WILLOWTREE PLANNING

REF: WTJ21 –151

**PROPERTY AT 48 VICTORIA ROAD AND 2A-2B GORDAN ROAD, ROZELLE
SSD-27208140**

We write in response to the **SSD-27208140**, for the St Aloysius College (SAC), Rozelle Campus. Specifically, this letter and attachments provides a response to the additional Request for Information (RFI) dated 27 May 2022. This RFI responds to the meeting held with Inner West Council and the Department of Planning and Environment (DPE) on the 23 May 2022. The applicant, St Aloysius College, and its specialist consultant team have reviewed and considered all matters raised in this RFI, which relate to traffic and heritage. **Table 1** below provides a detailed response to the key matters raised and outlines the proposed amendments to comply with these matters.

Swept Path Analysis

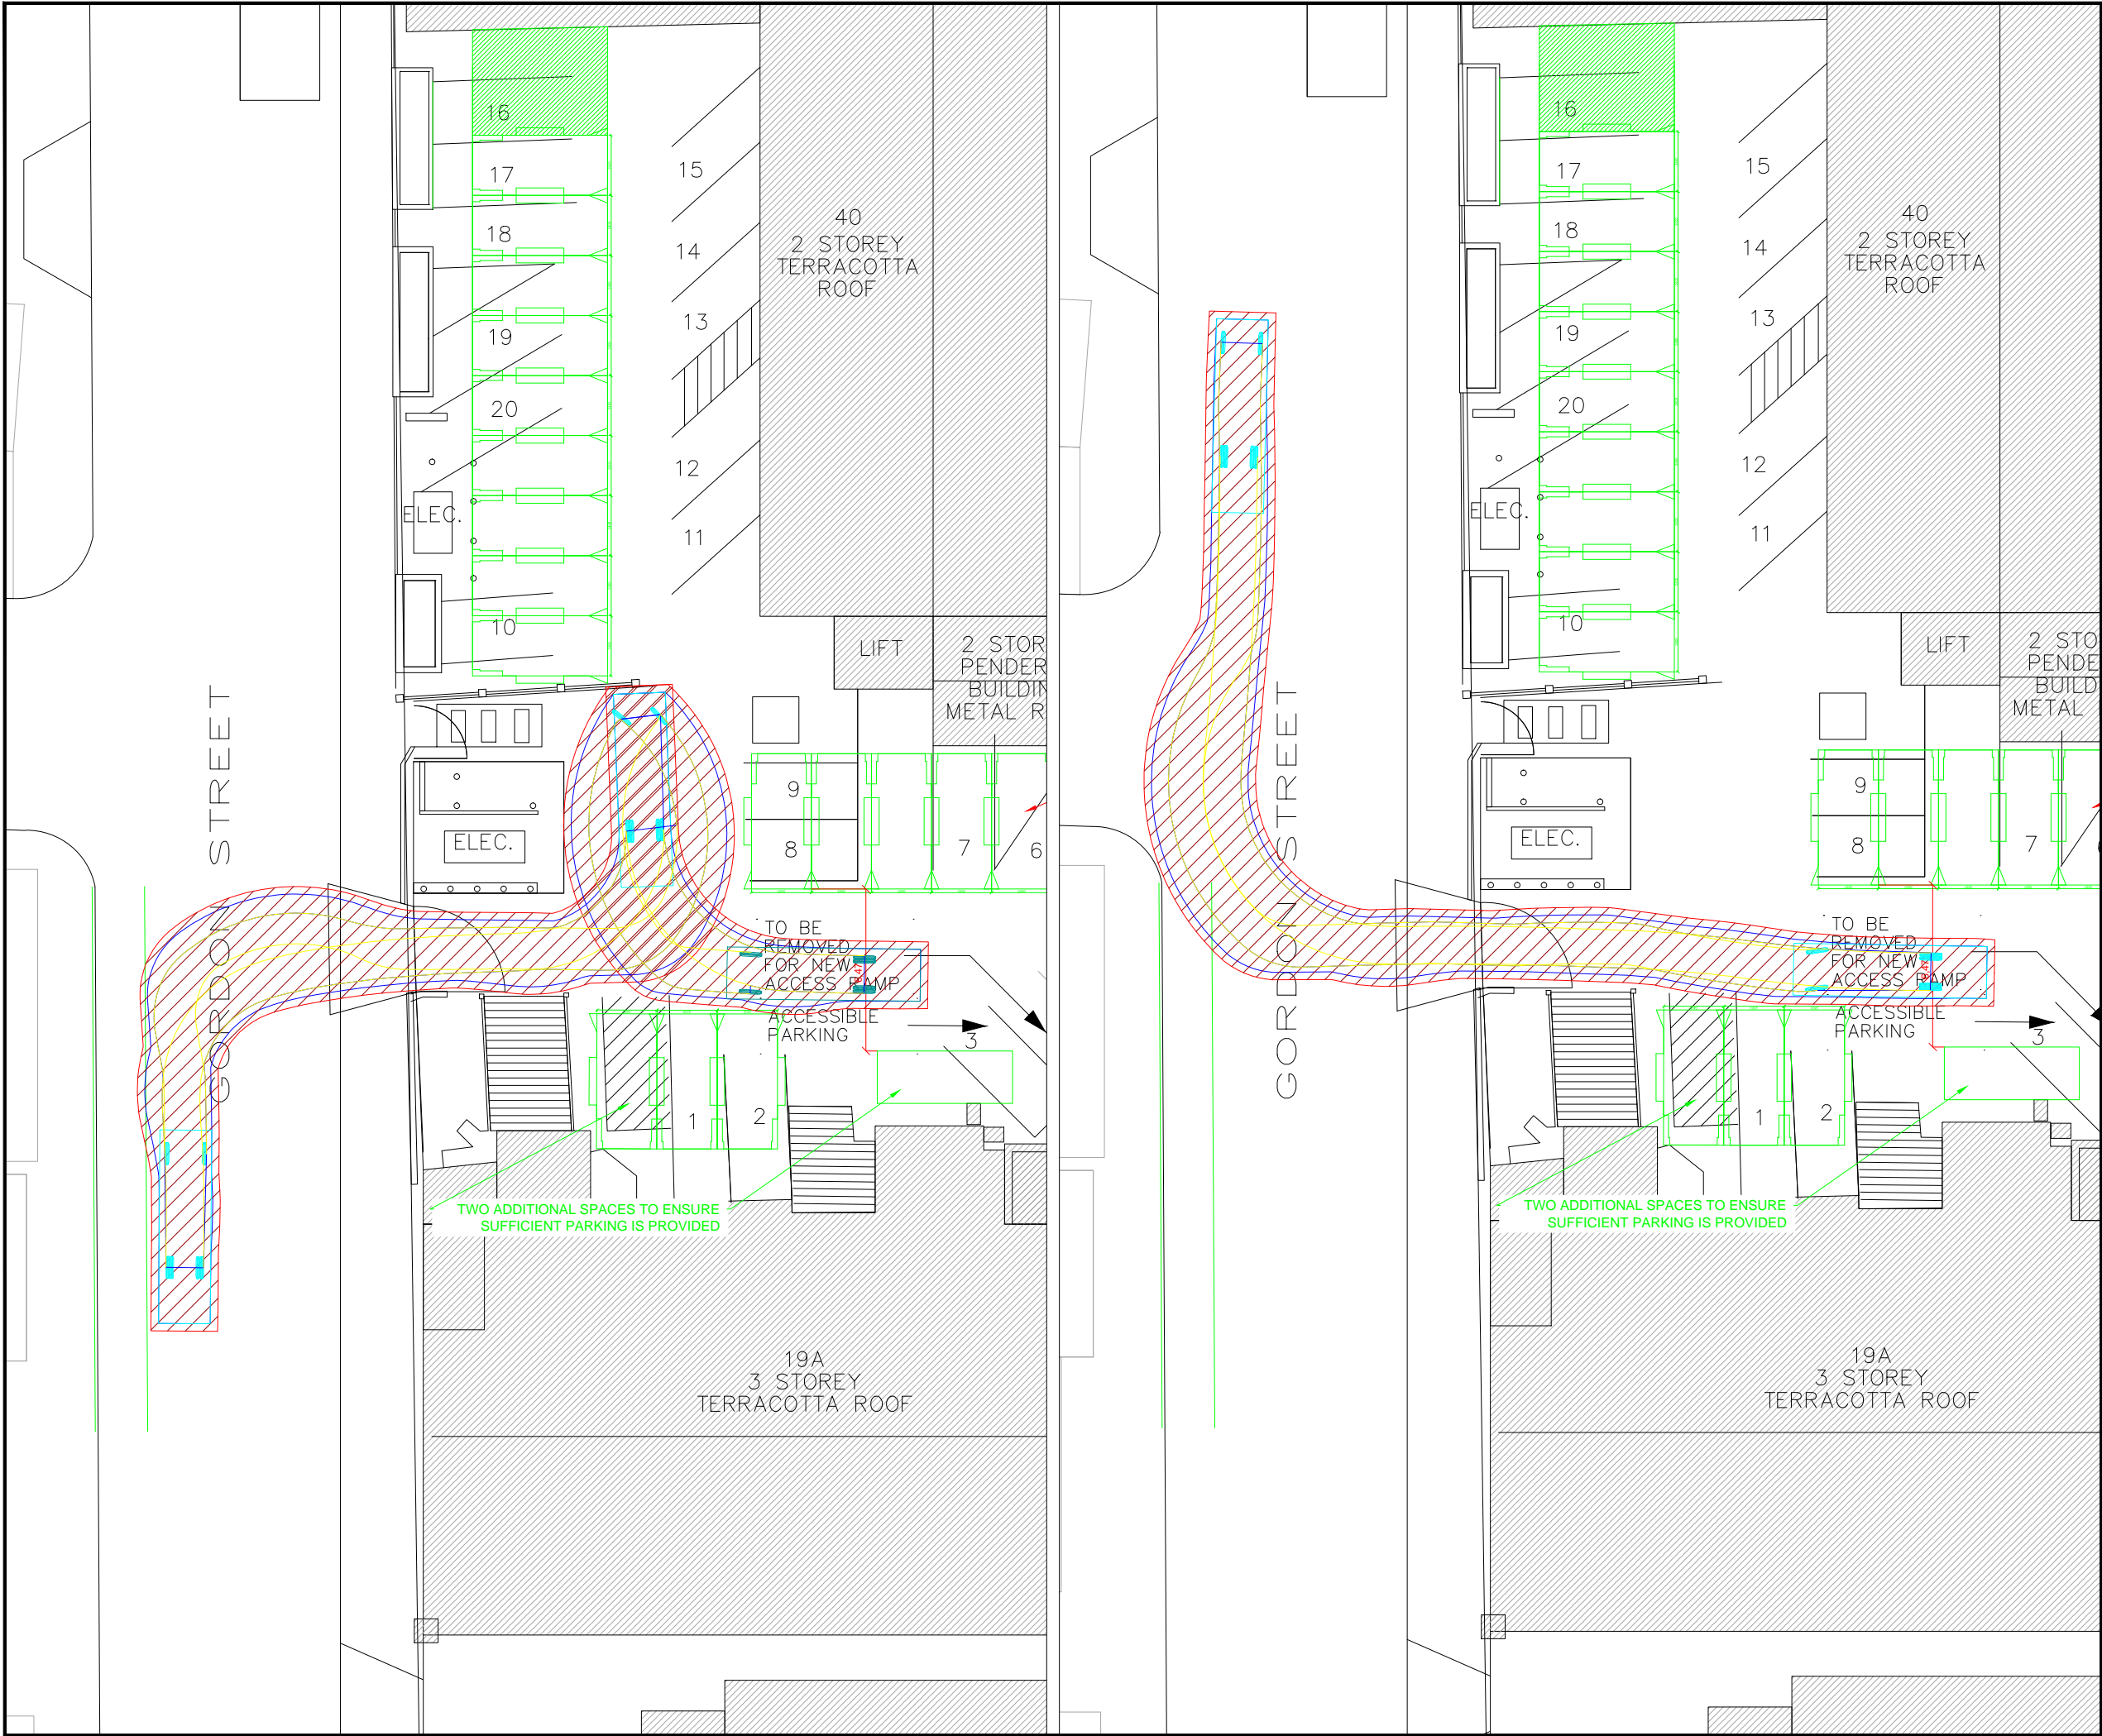
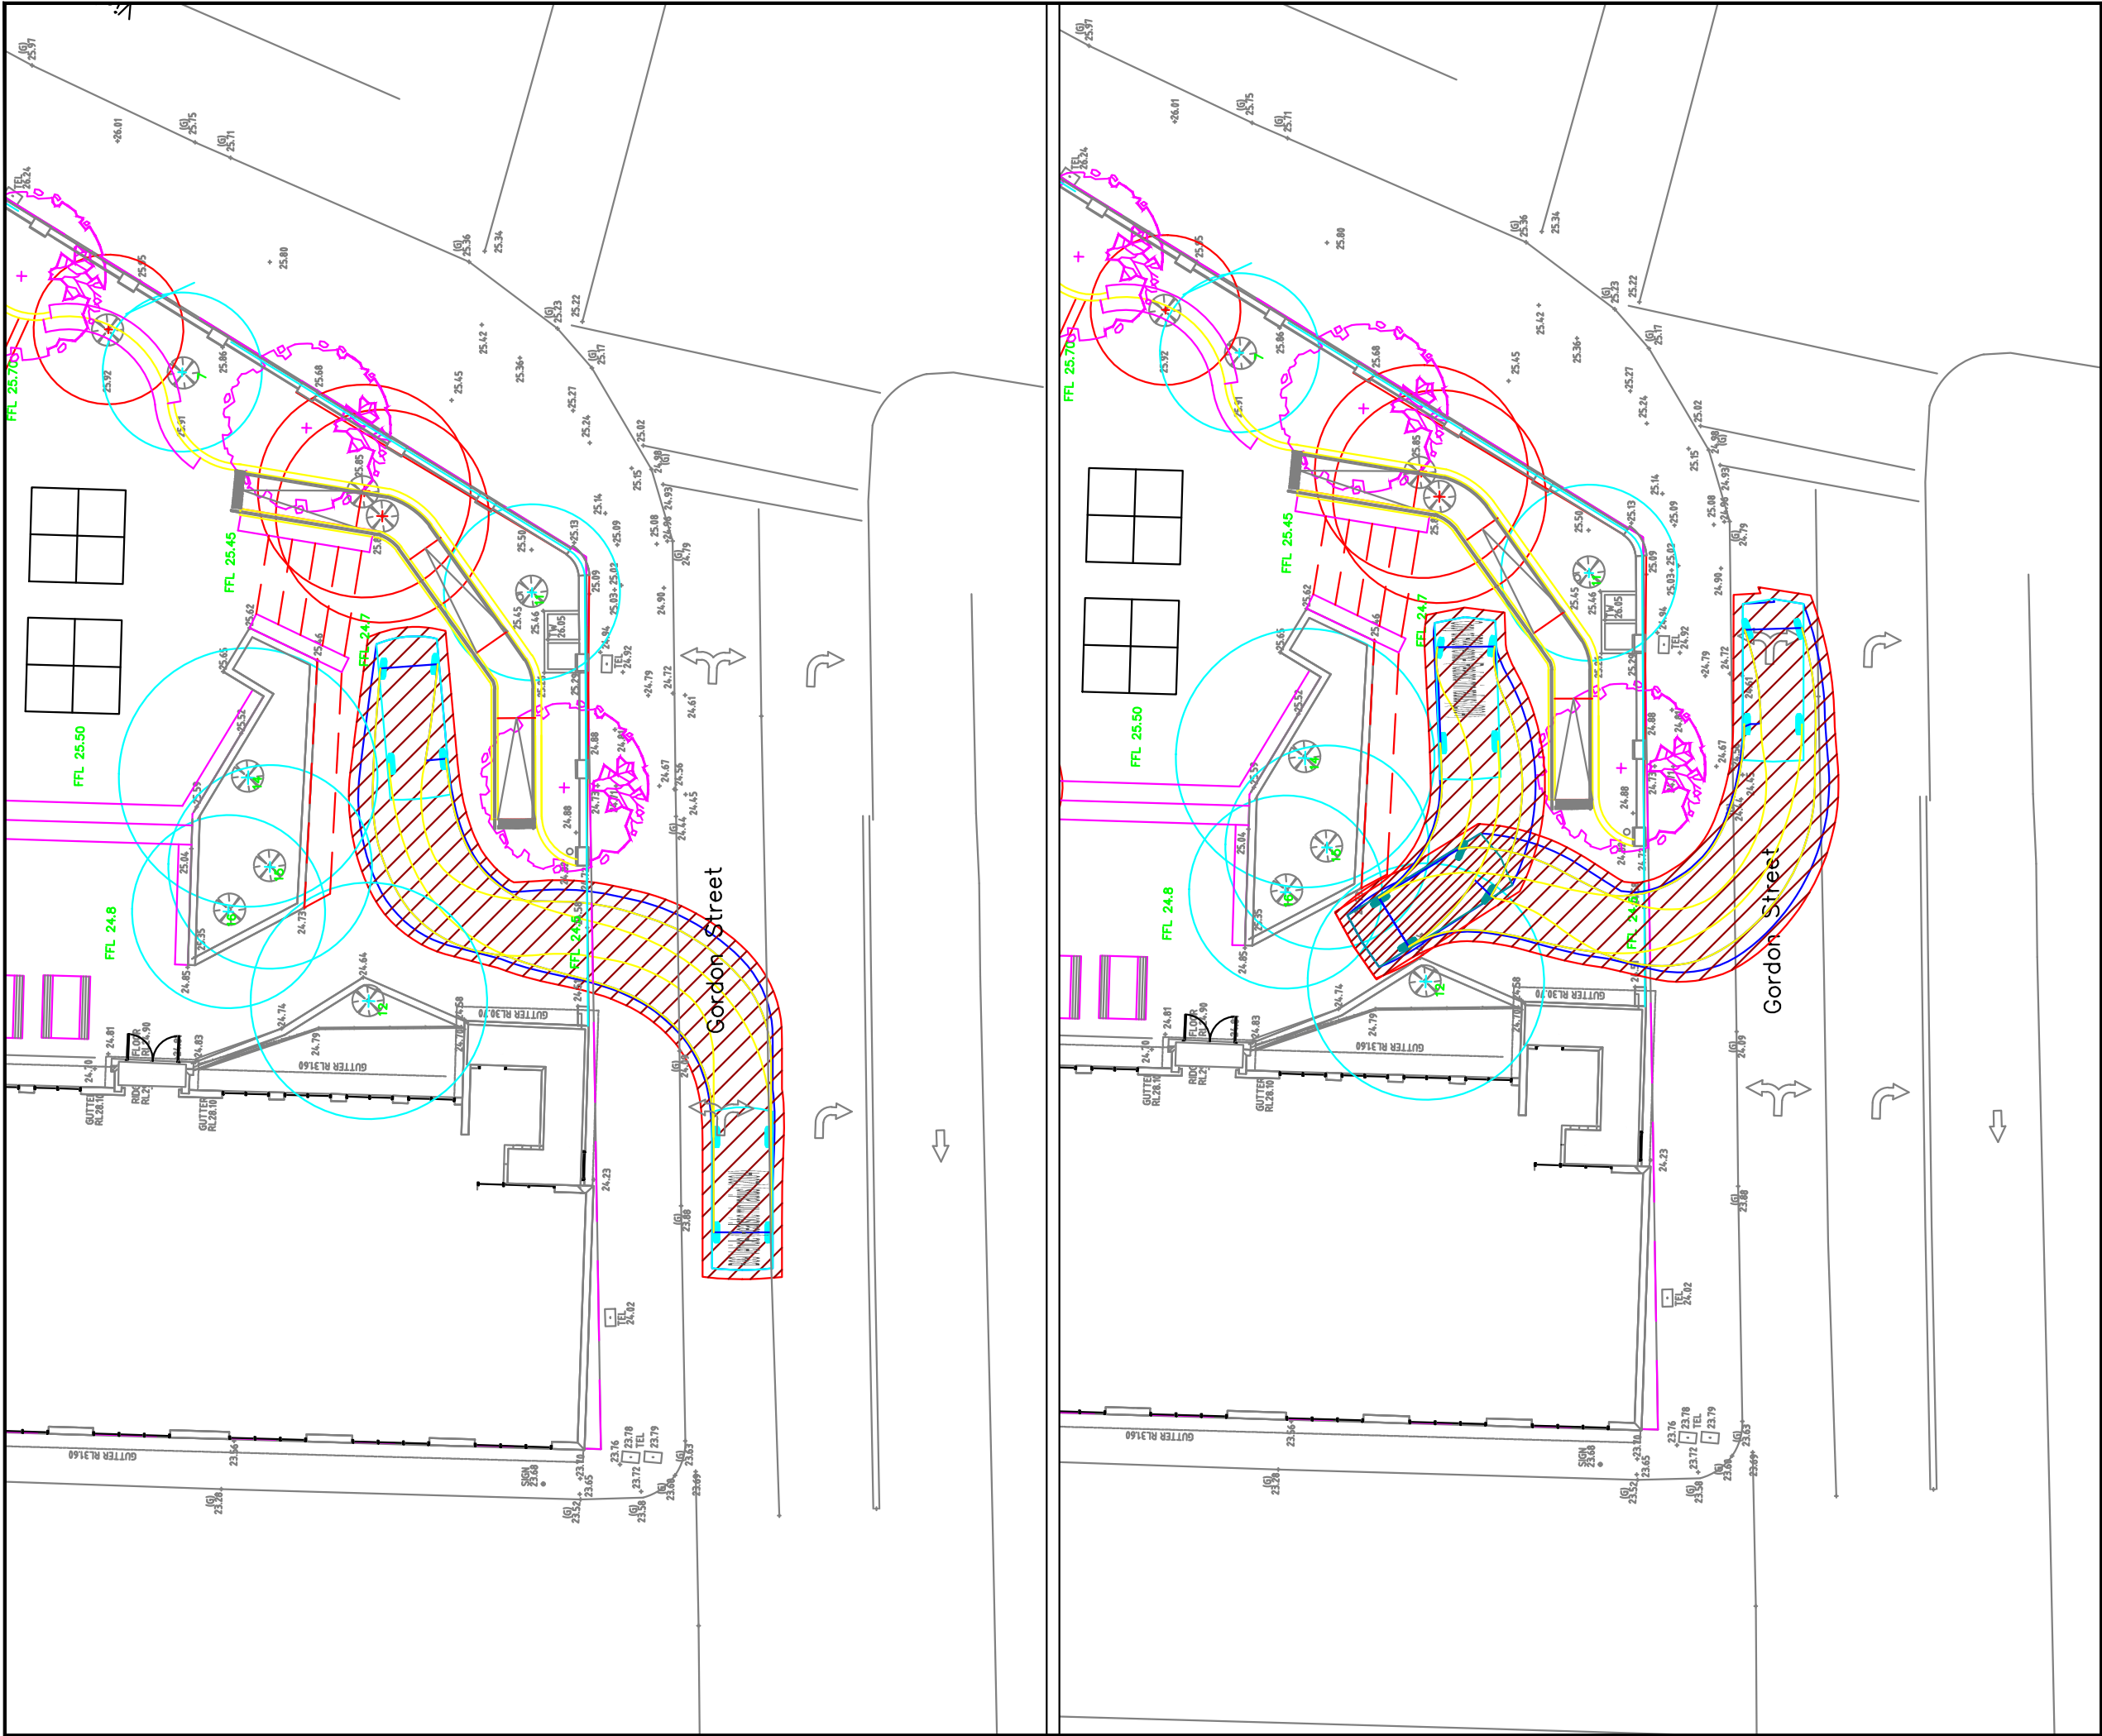
<p>2. Shuttle Bus Swept Paths</p>	
<p>As shown in Figure 1 below, the swept paths show that the manoeuvre is very tight, and the gate encroaches within the 300mm clearance bands either side of the vehicle. Further investigation should be undertaken to explore whether there is scope to widen the entry gates and driveway.</p>	<p>The updated swept path provided within Appendix H of the TAIA report (Appendix 2) shows that there is sufficient width of the driveway to accommodate both the body of the vehicle and the 300mm clearance on either side of the vehicle (red line) which meets the requirements of AS 2890.2 (2018).</p> <p>This is addressed in further within the TAIA (Appendix 2) and traffic response (Appendix 3).</p>

As shown in Figure 2 below, the swept path also details that the shuttle bus will impact a bollard protecting the electricity substation and drops off the edge of the kerb shown circled in red (Figure 3). Further investigation should be undertaken to explore whether there is scope to set the kerb back and to relocate the bollard to allow for better manoeuvrability of the shuttle bus.

The swept path analysis has been amended and is presented in Appendix H of the TAIA (**Appendix 2**). This updated swept path analysis shows that the shuttle bus can manoeuvre clear of the bollards, with a 300mm clearance on either side of the vehicle.
